# Principal Areas of Disagreement Summary Statement (PADSS)

Version Number: **42**

This statement has been prepared by Horsham District Council (“the Council”) with input from the joint local authorities, technical consultants and legal specialists. The Northern Runway Project application was submitted to the Planning Inspectorate on 6 July 2023 and accepted for Examination on 3 August 2023. The Council is one of the local authorities identified by Section 43(2) of the Planning Act 2008 and in response to the Examining Authority’s (“ExA”) Procedural Decision letter of 8 September 2023 to the Applicant and the Host and Neighbouring Authorities, the Council has prepared this Principal Areas of Disagreement Summary Statement (“PADSS”) (Version 2). This Statement identifies the principal areas of disagreement and is considered to be a live document.

Diagram 3.3.9: Model performance before and after adjustment, London zone

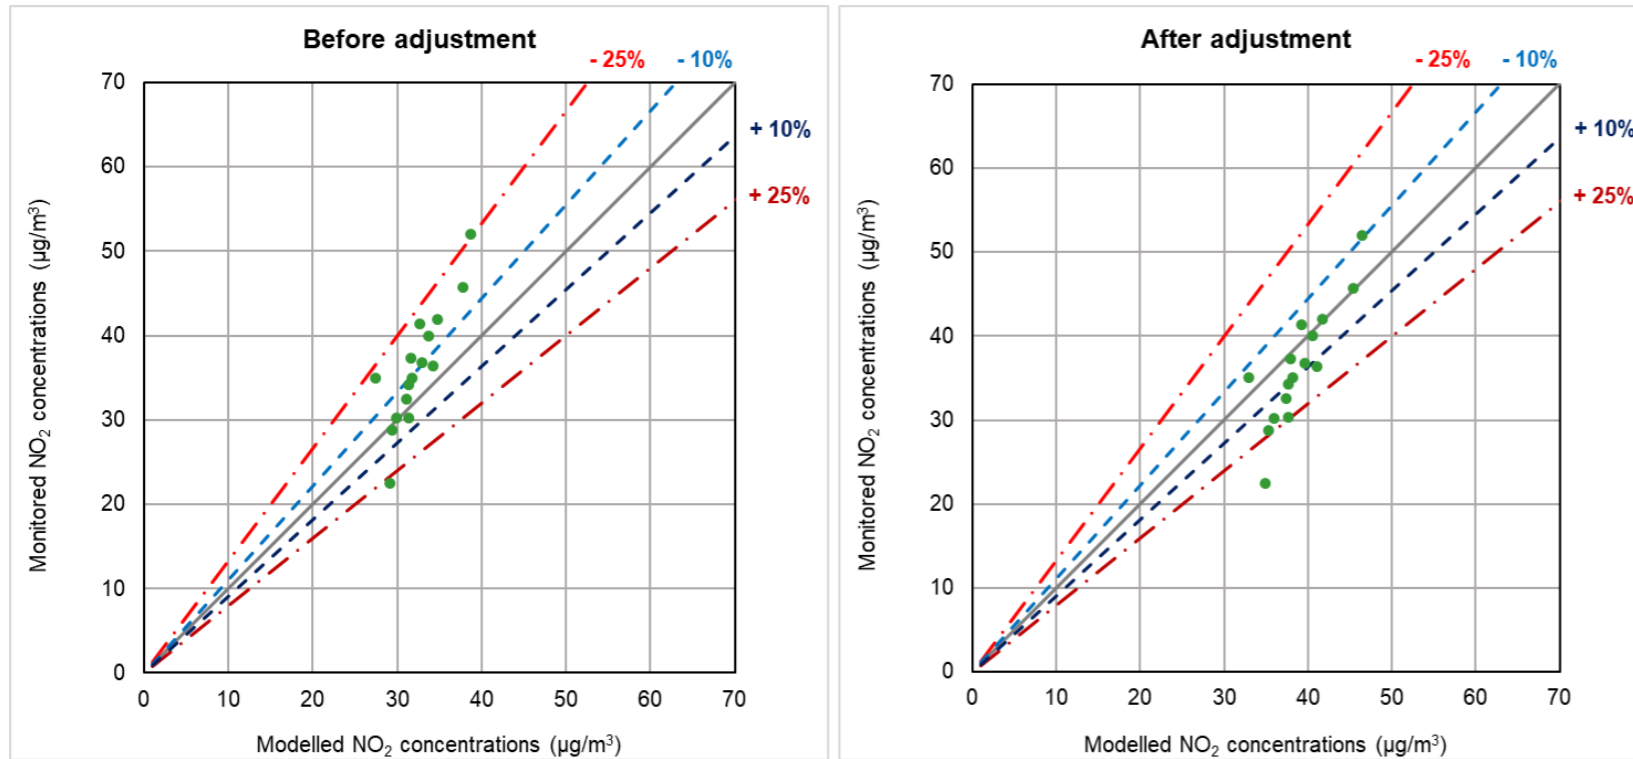
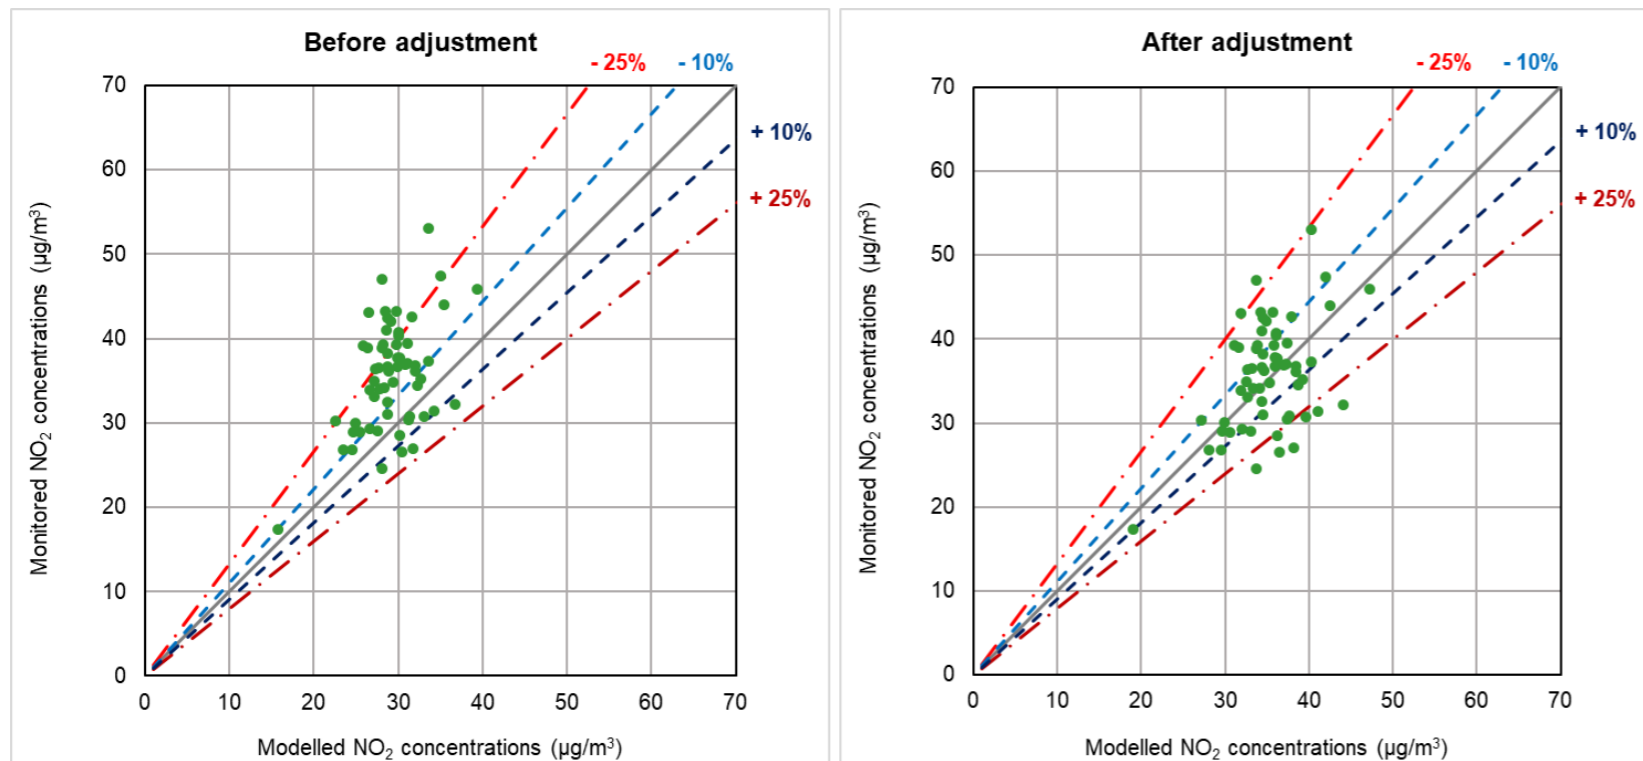
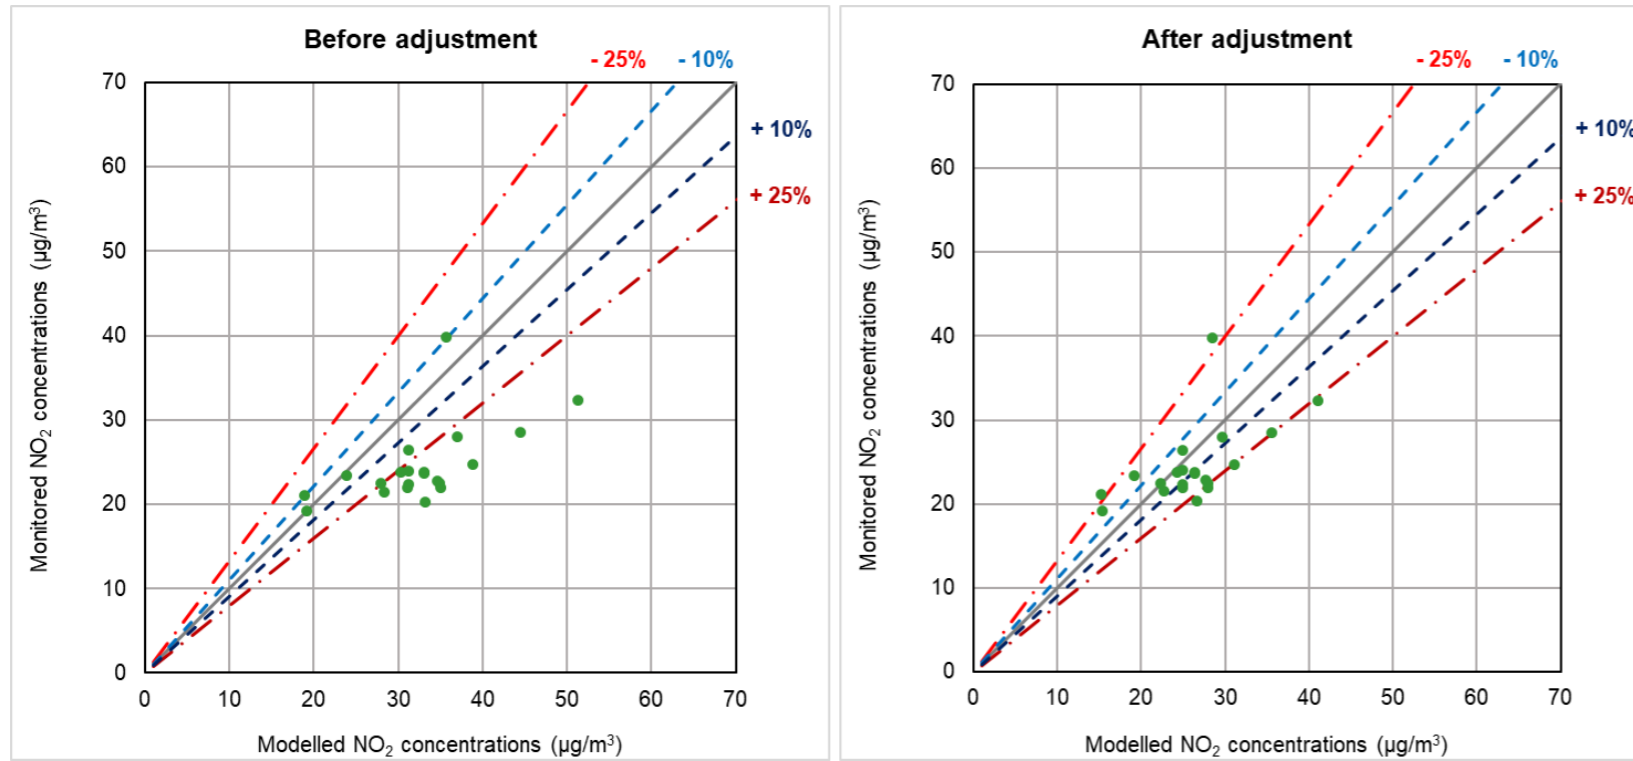
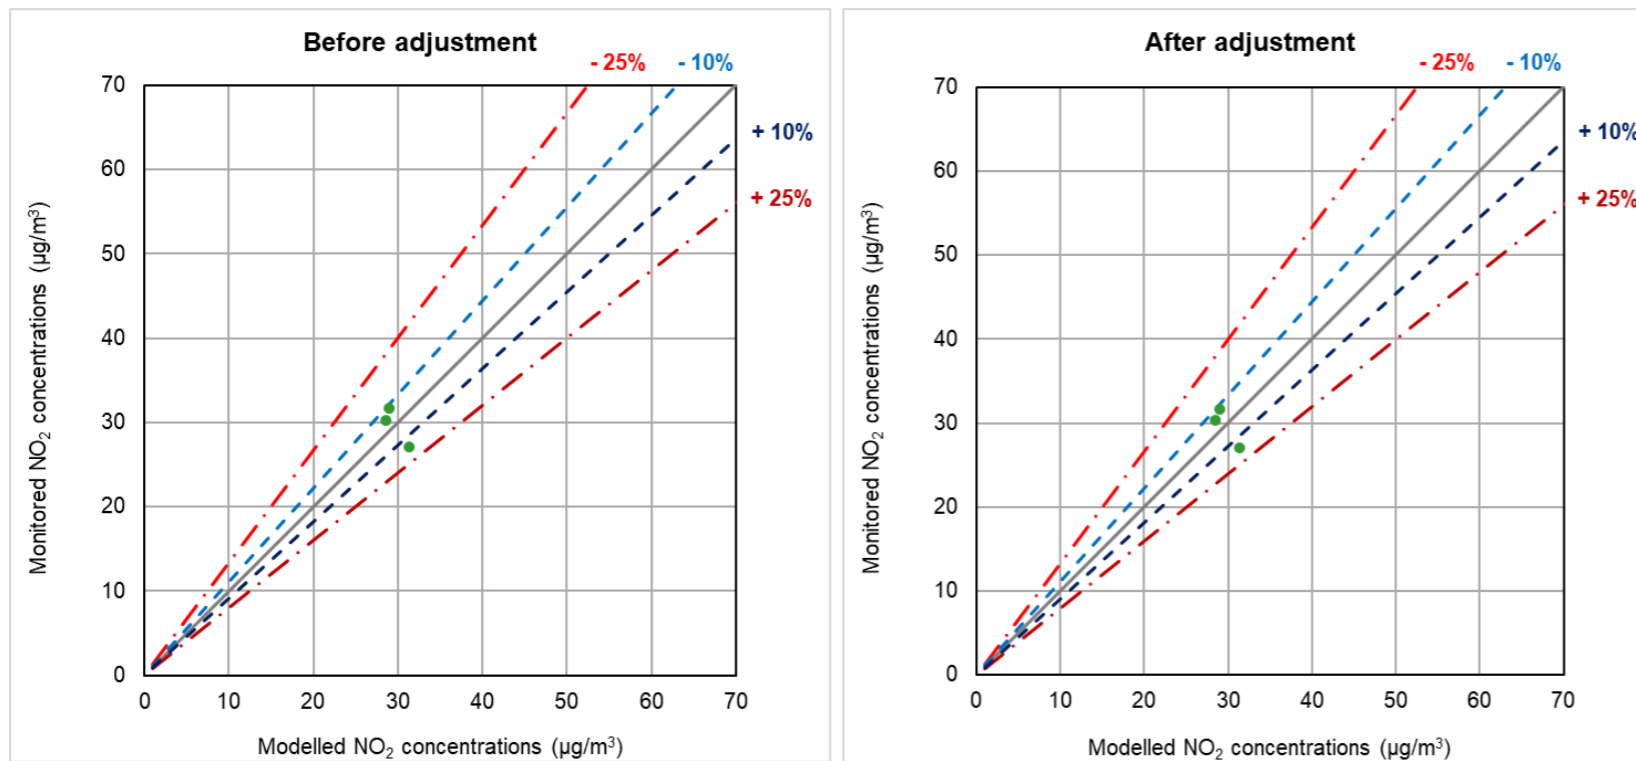
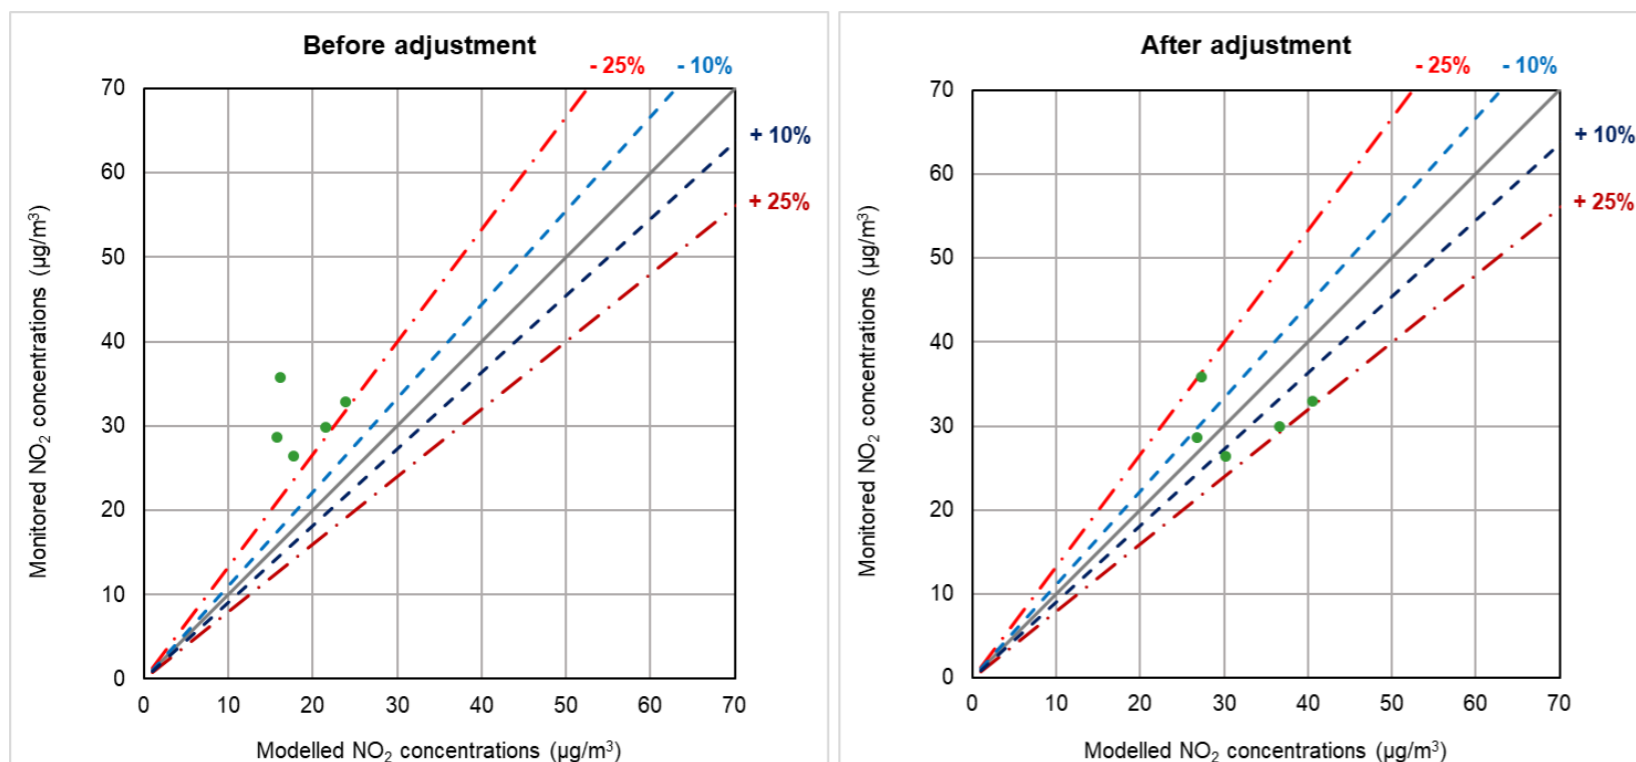
3.5	Model Set Up and Methodology	<p>Regarding model verification, Appendix 13.6.1: Air Quality Data and Model verification is missing details on how model verification factors for the selected zones were established. Details are required of the initial verification including Monitored Road NOx Contribution versus Unverified Modelled Road NOx, which monitoring sites were used, and which were removed from the verification process.</p> <p>To facilitate the scrutiny of the model set up and any assumptions used, it is requested that a complete set of input files be shared for 2018 (Base Year) and 2029 (nearest future year). In addition, Operational and Construction impacts for 2029 should be modelled jointly as one scenario, in order to enable the evaluation of all impacts associated with the development.</p>	The Applicant should provide further details in relation to the model verification	Uncertain
